Your Ref: 2017/94019
Our Ref: T019677

15th December 2017

The Orchards, St Mary's Avenue, Netherthong, Holmfirth - Discharge condition 11 (drainage) on previous application 2014/91533 for outline application for erection of residential development

Scale	1:200	Drawn	KB	Checked	VB
Date	FEB'16	Status	PRELIMINARY		
Drg. No.	16293/006			Rev.	P3

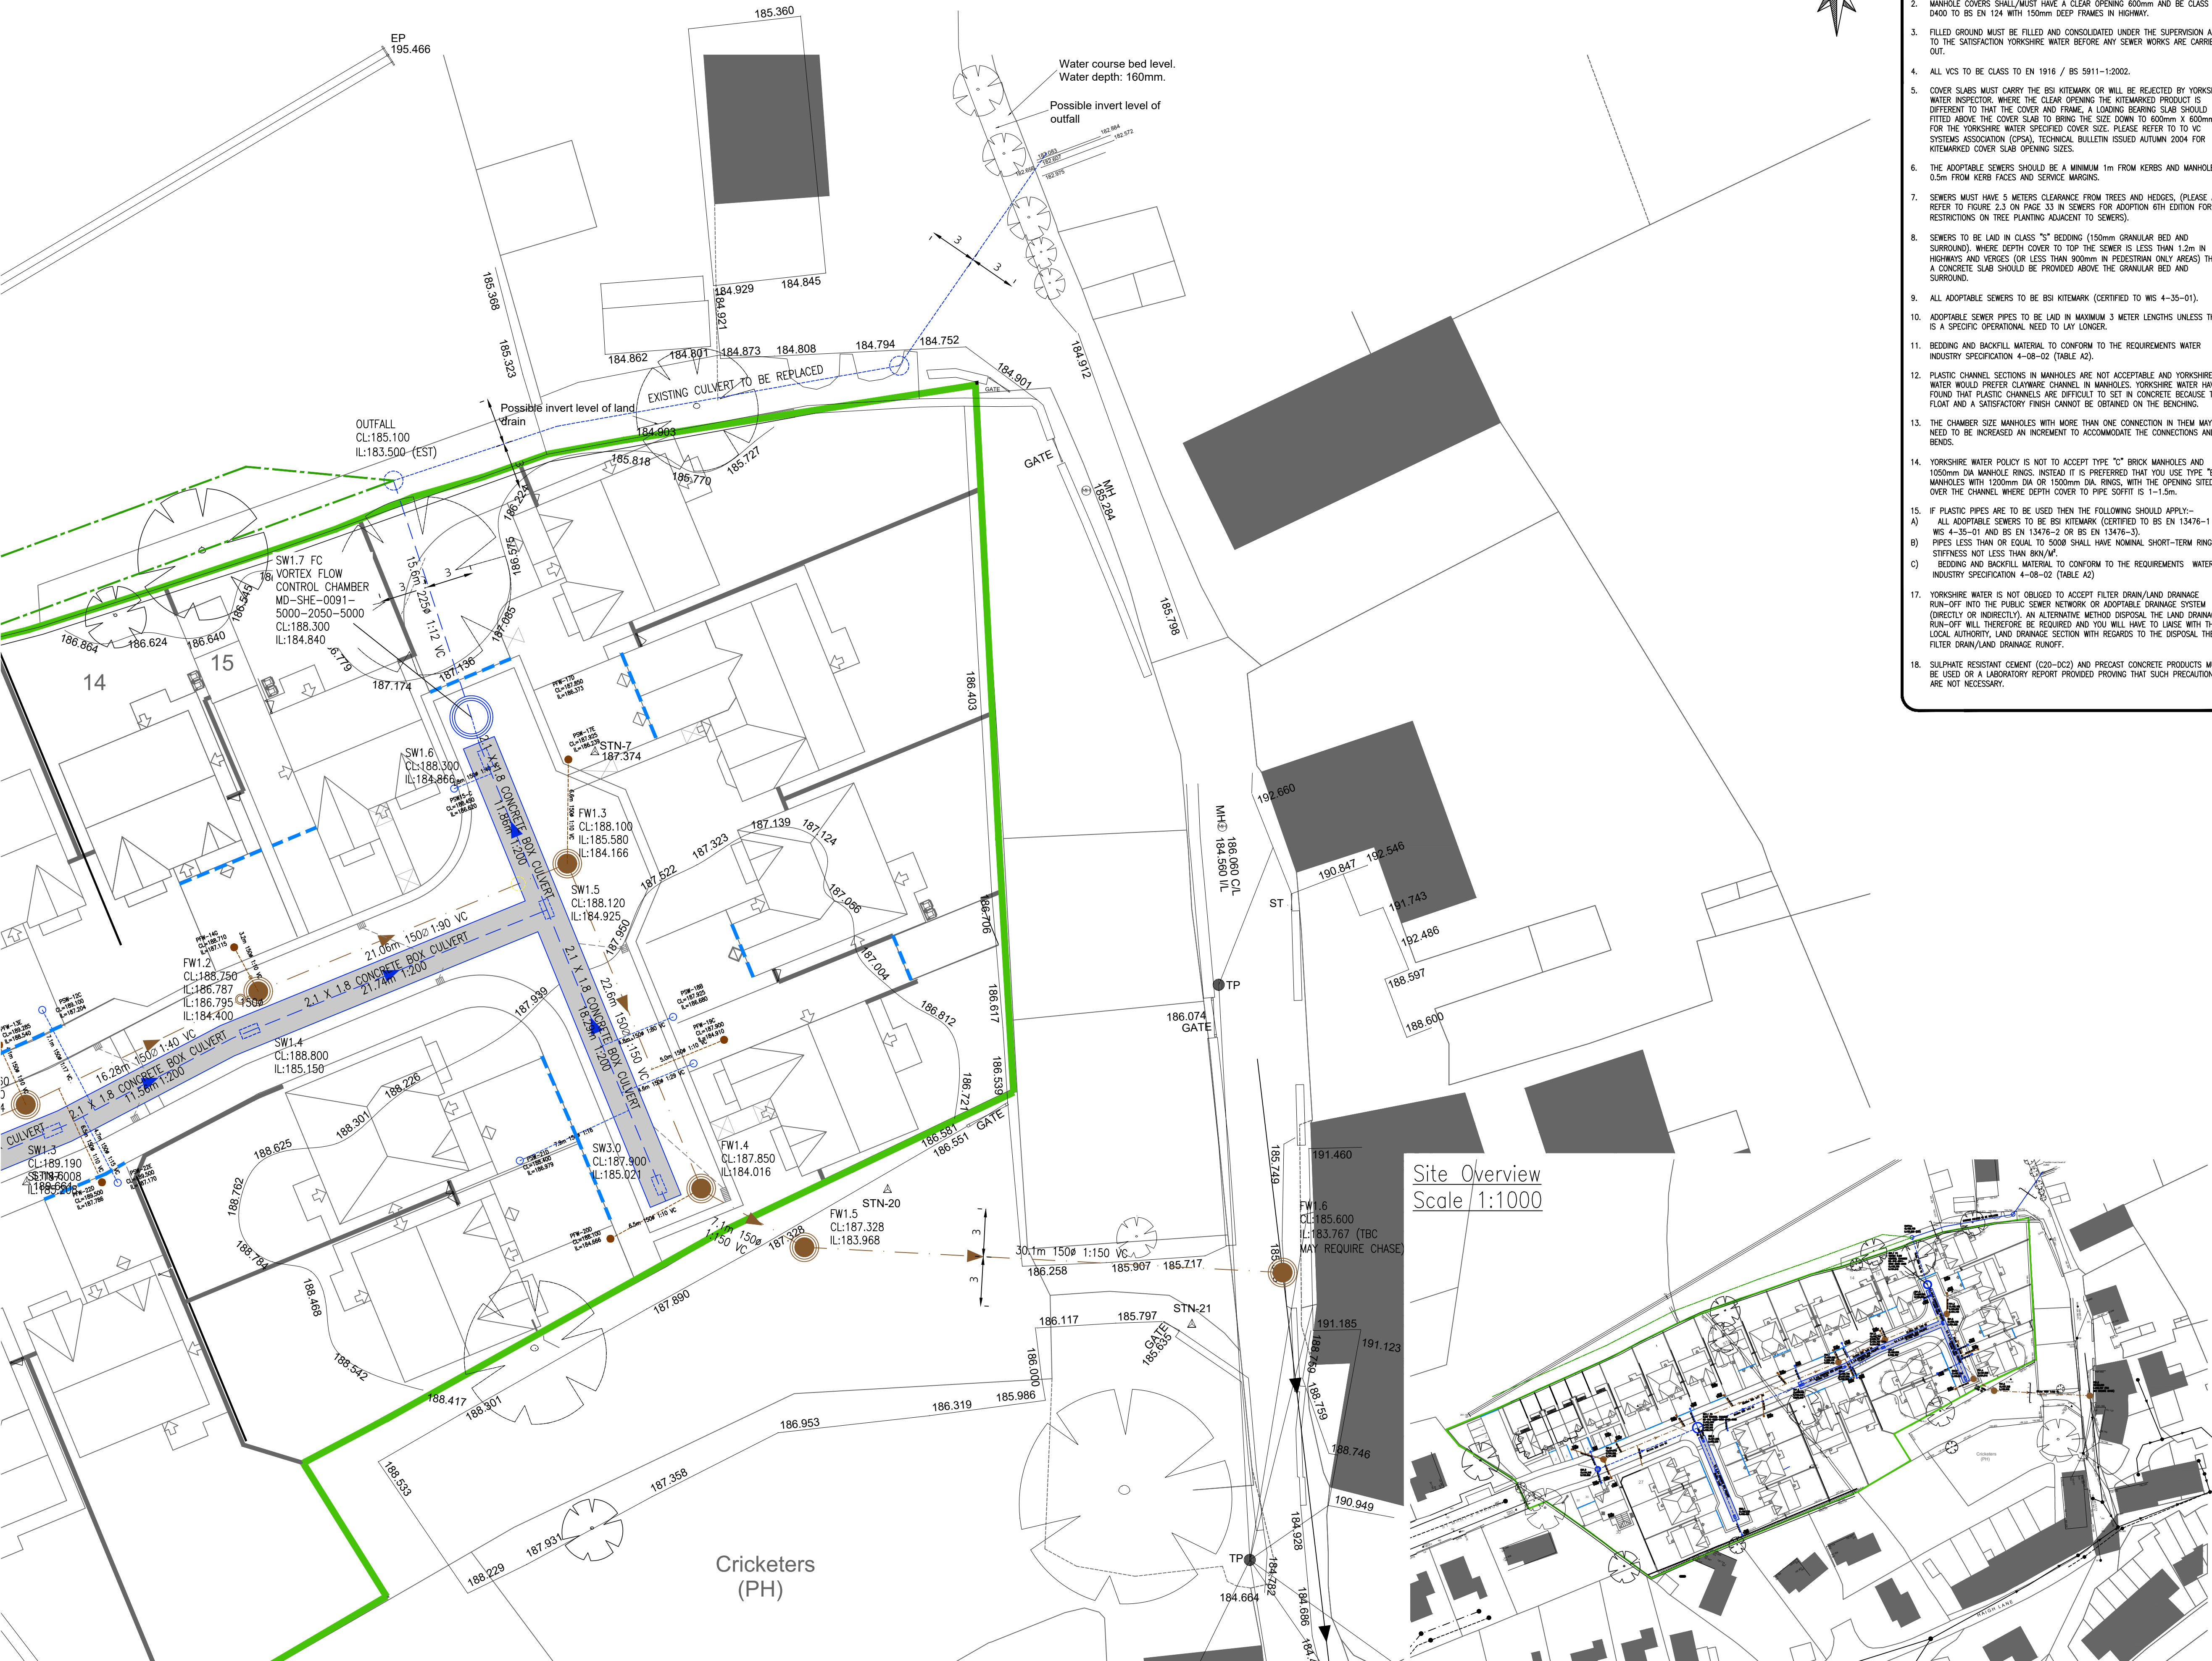
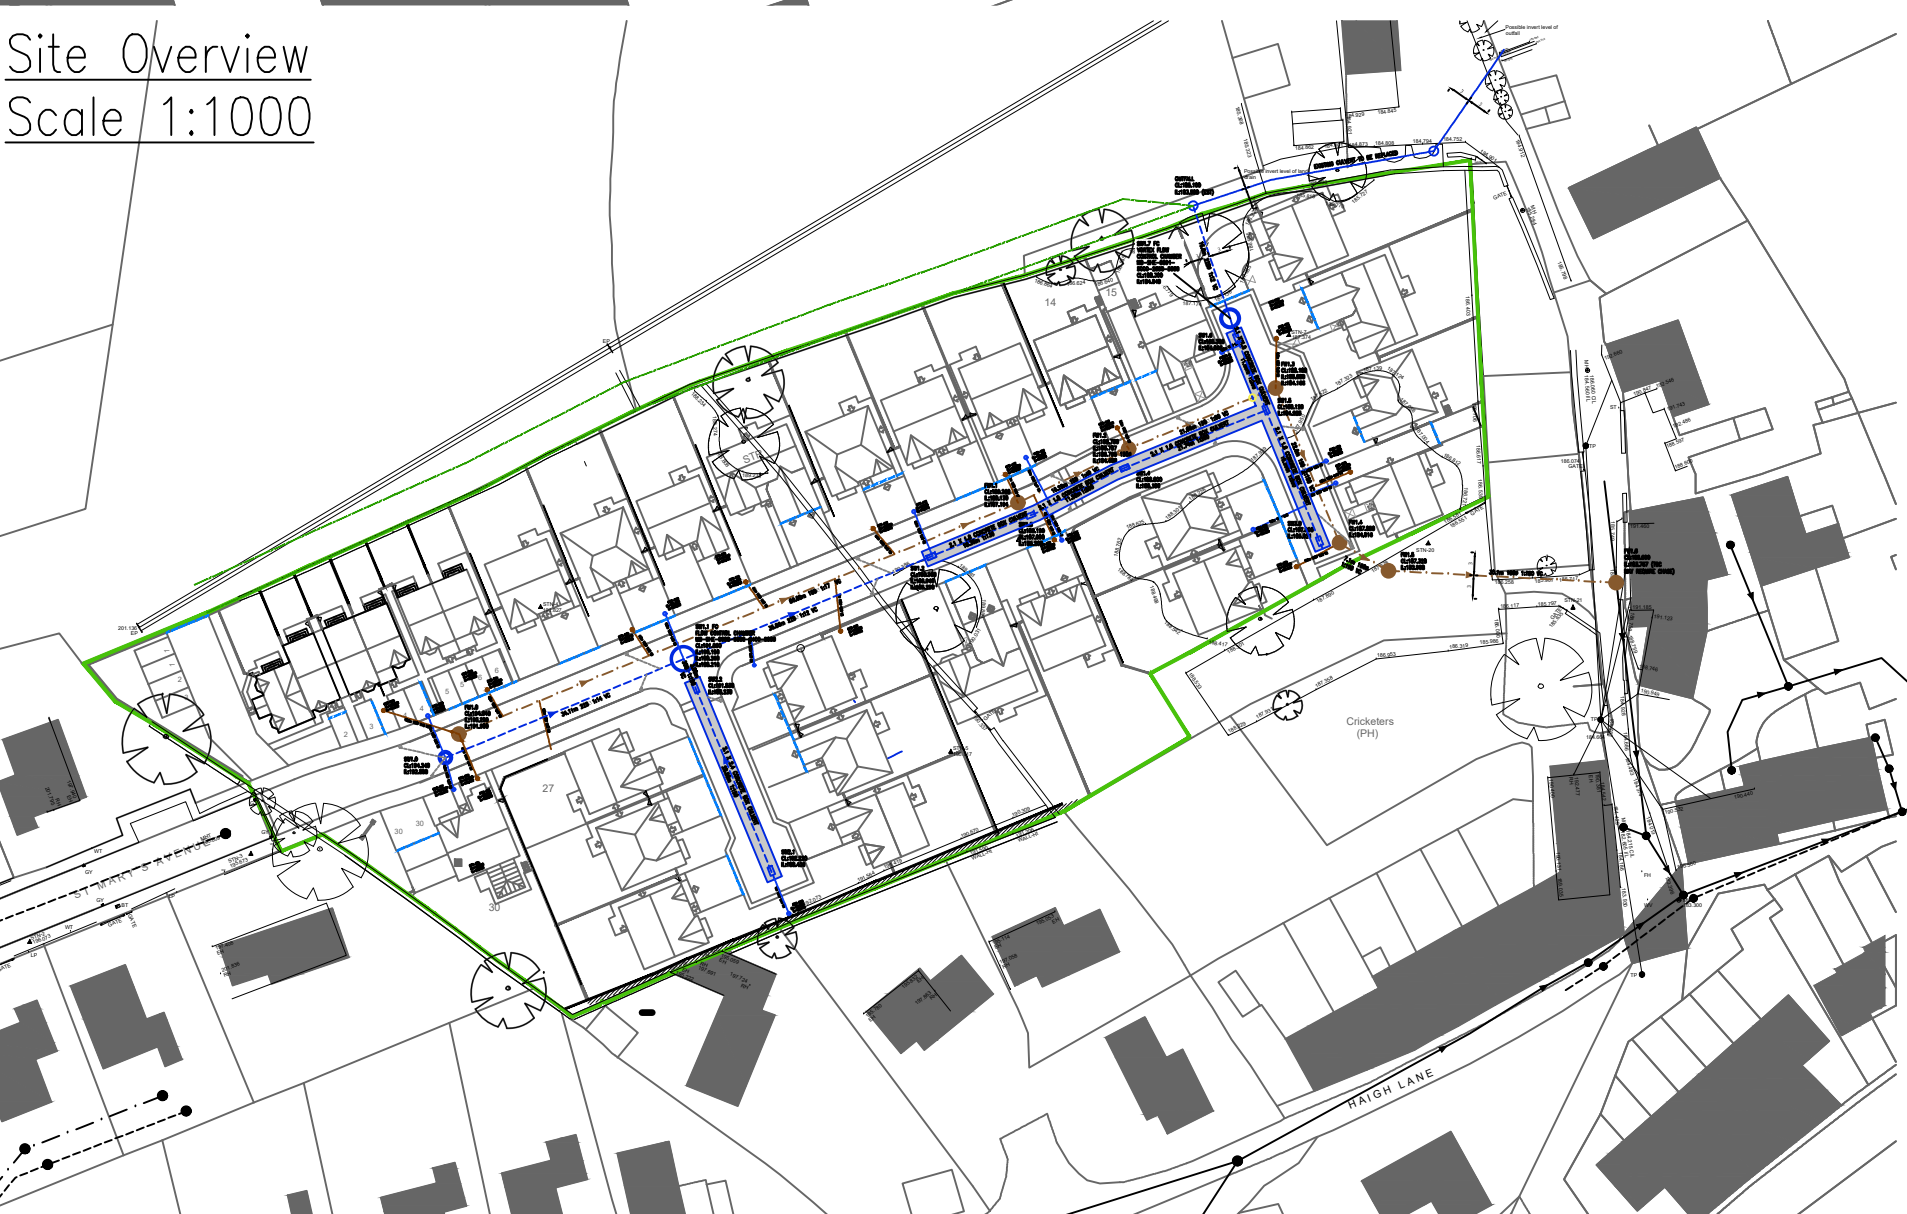
- 1) The proposed separate systems of drainage on site and off site
- 2) The anticipated amount of domestic foul water to be discharged to the public combined sewer
- 3) The proposed point of discharge of foul water to the respective public sewer

submitted on drawing 16293/006 (revision P3) dated 14/07/2017 that has been prepared by Dudleys.

The submitted drawing shows surface water proposed to be drained to Land Drain.

The developer should also note that the site drainage details submitted have not been approved for the purposes of adoption or diversion. If the developer wishes to have the sewers included in a sewer adoption/diversion agreement with Yorkshire Water (under Sections 104 and 185 of the Water Industry Act 1991), they should contact our Developer Services Team (tel 0345 120 84 82, email: technical.sewerage@yorkshirewater.co.uk) at the earliest opportunity. Sewers intended for adoption and diversion should be designed and constructed in accordance with the WRc publication 'Sewers for Adoption - a design and construction guide for developers' 6th Edition, as supplemented by Yorkshire Water's requirements.

Given the above comments, condition 11 can be discharged.
